PEMULWUY DEVELOPMENT (Precinct 3) – Design Review Panel Meeting No.4

DATE: 07/03/2017

Massing Option 2 Precinct 3 - Pemulwuy Mixed Use Development, REDFERN

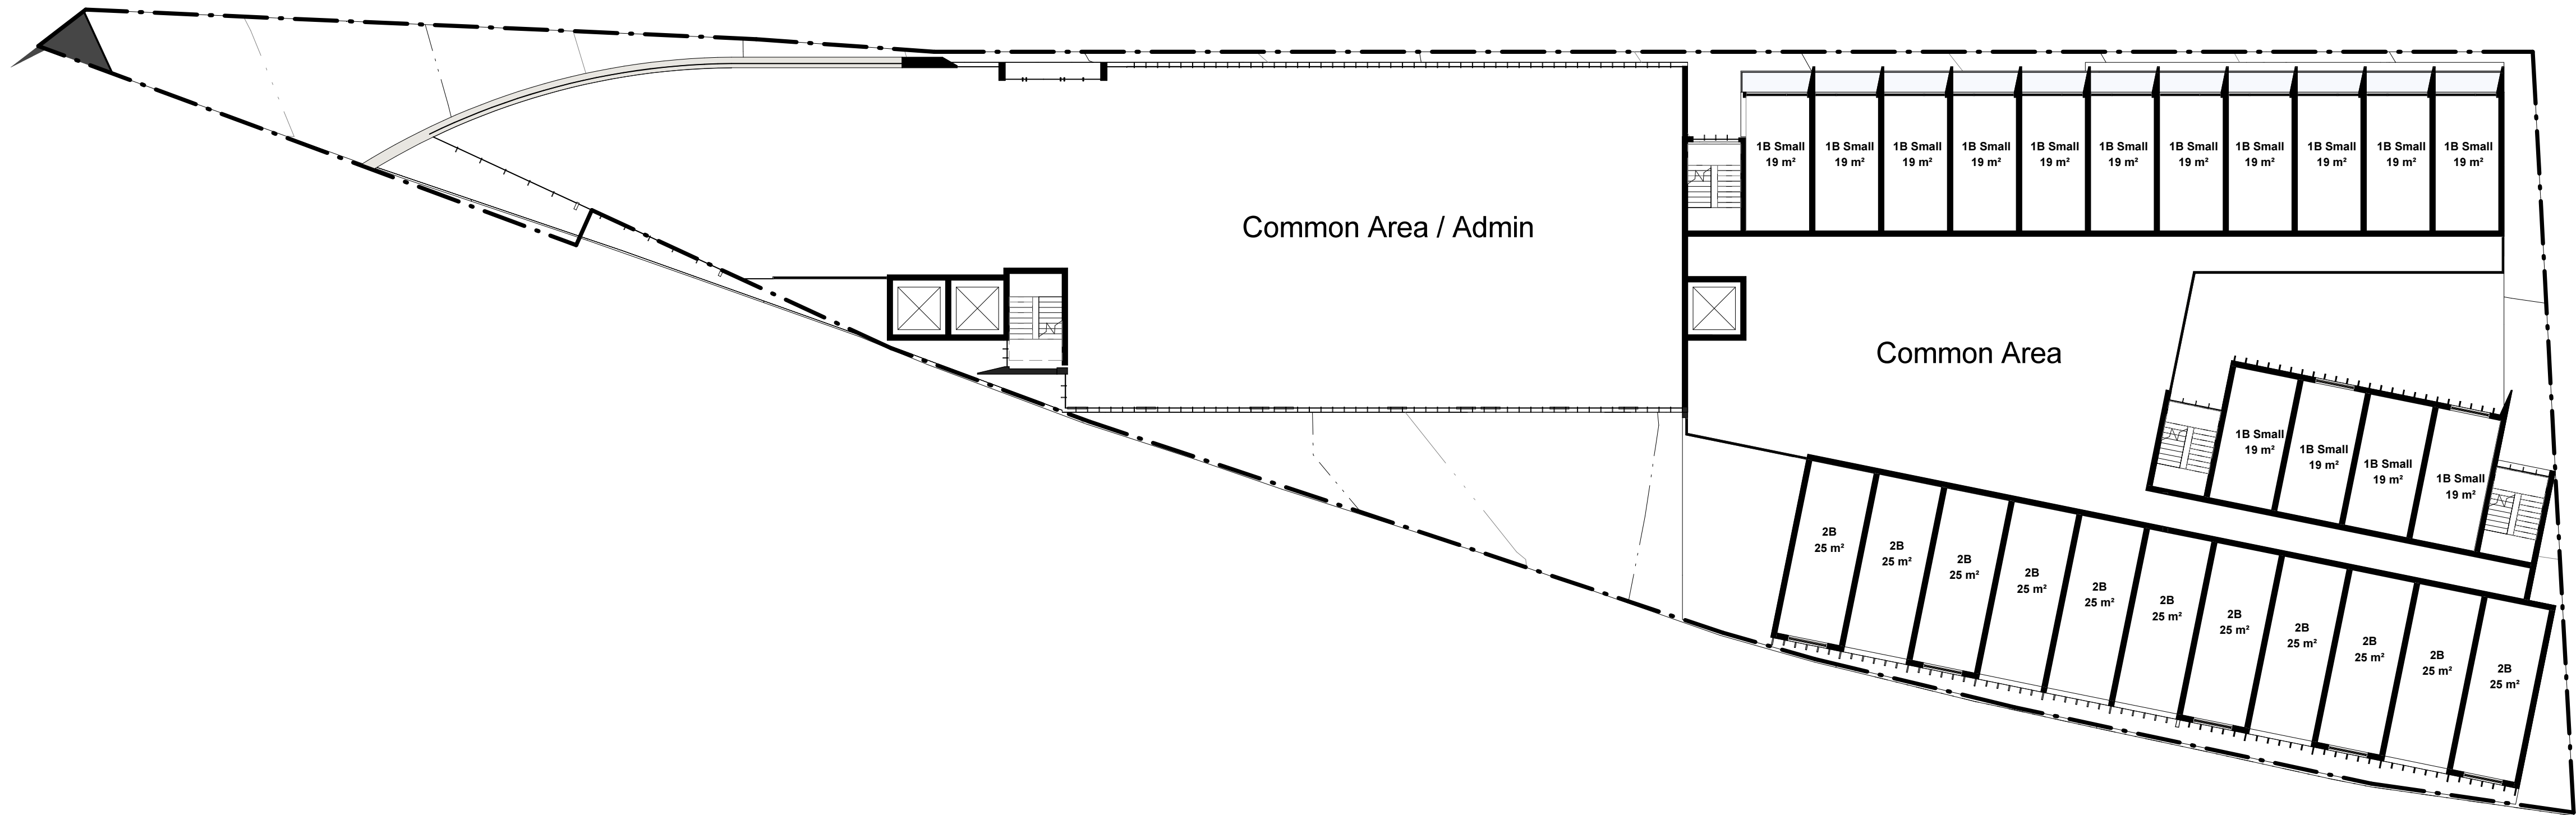
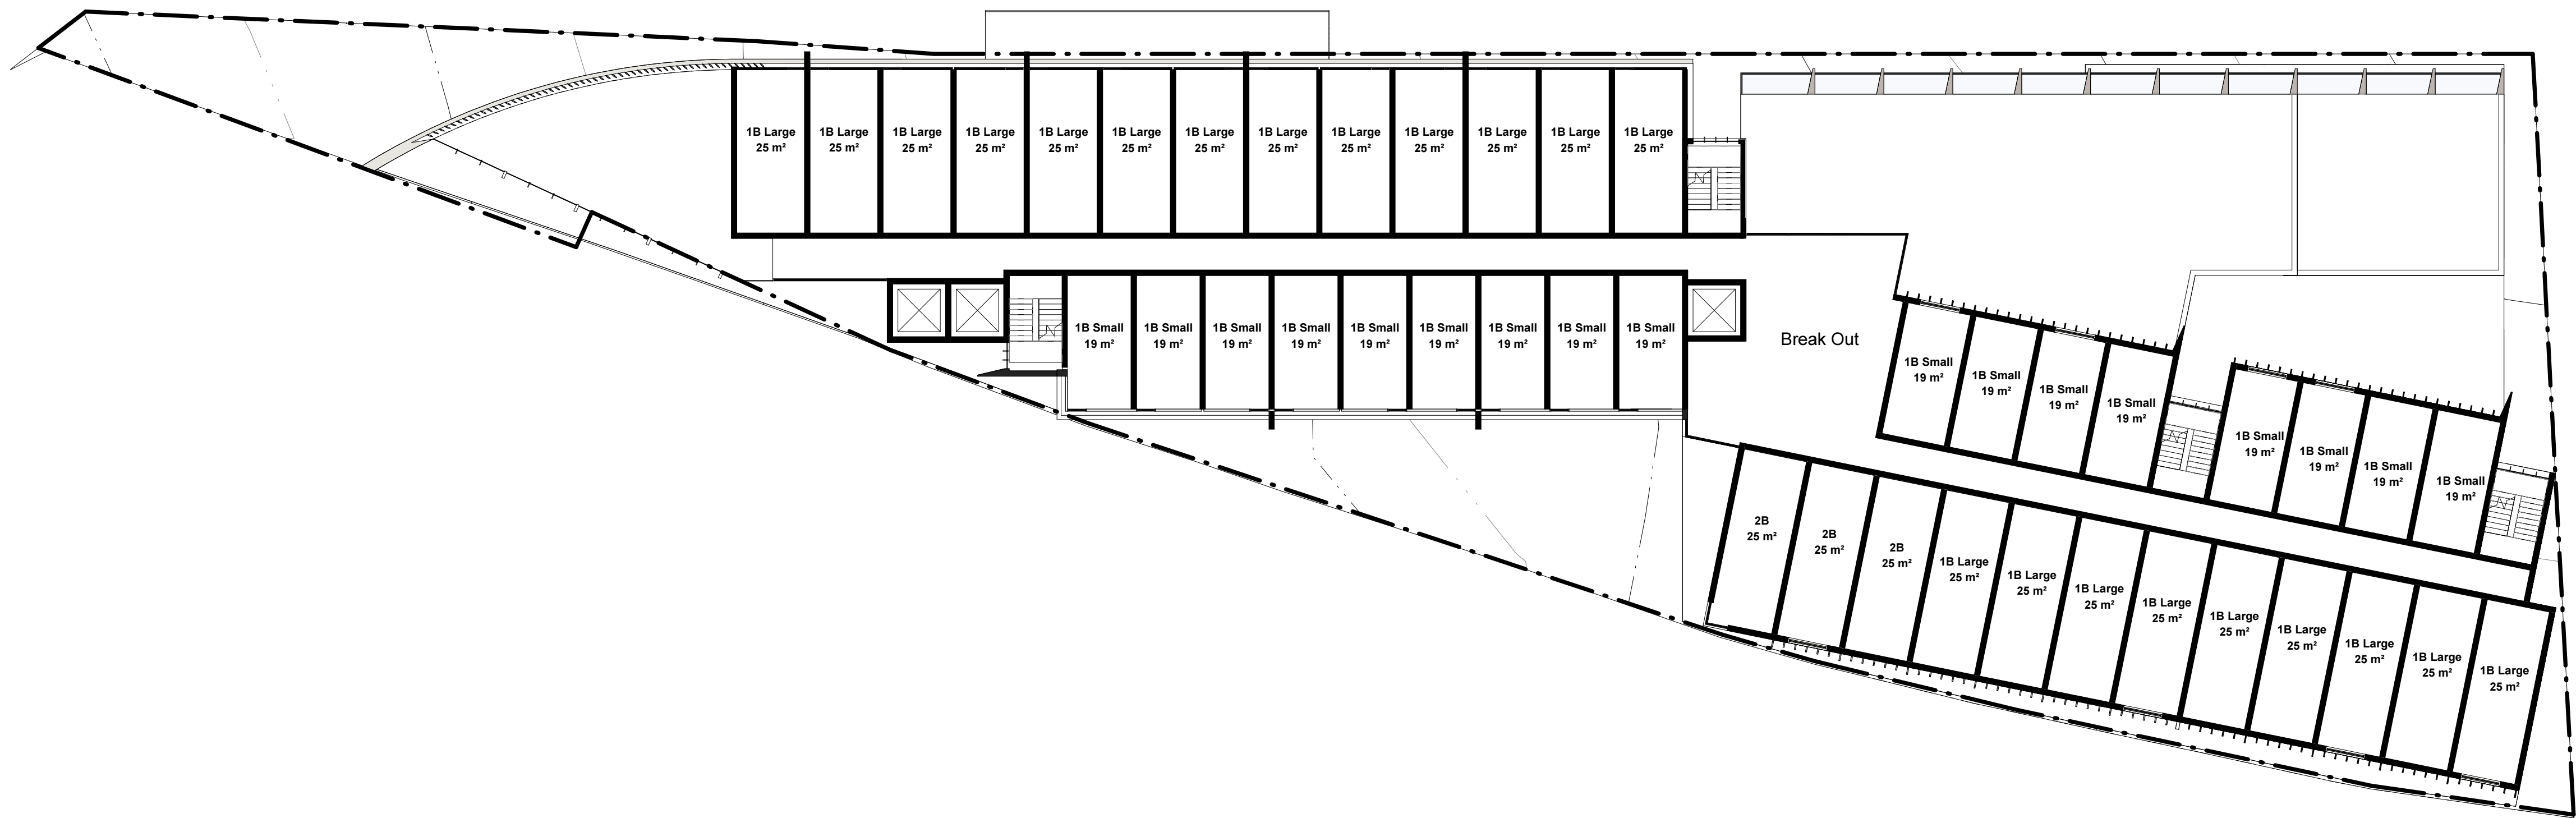
4.4.4	Acknowledging that the design team's current preferred option is broadly consistent with the maximum height of the SEARs scheme, the panel nevertheless encourage further exploration of Option 2 to determine if additional height could offer demonstrable benefits to residential and public realm amenity as well as an improved overall urban response. This would not appear to require significant revision of floor planning to explore modified built form profiles.
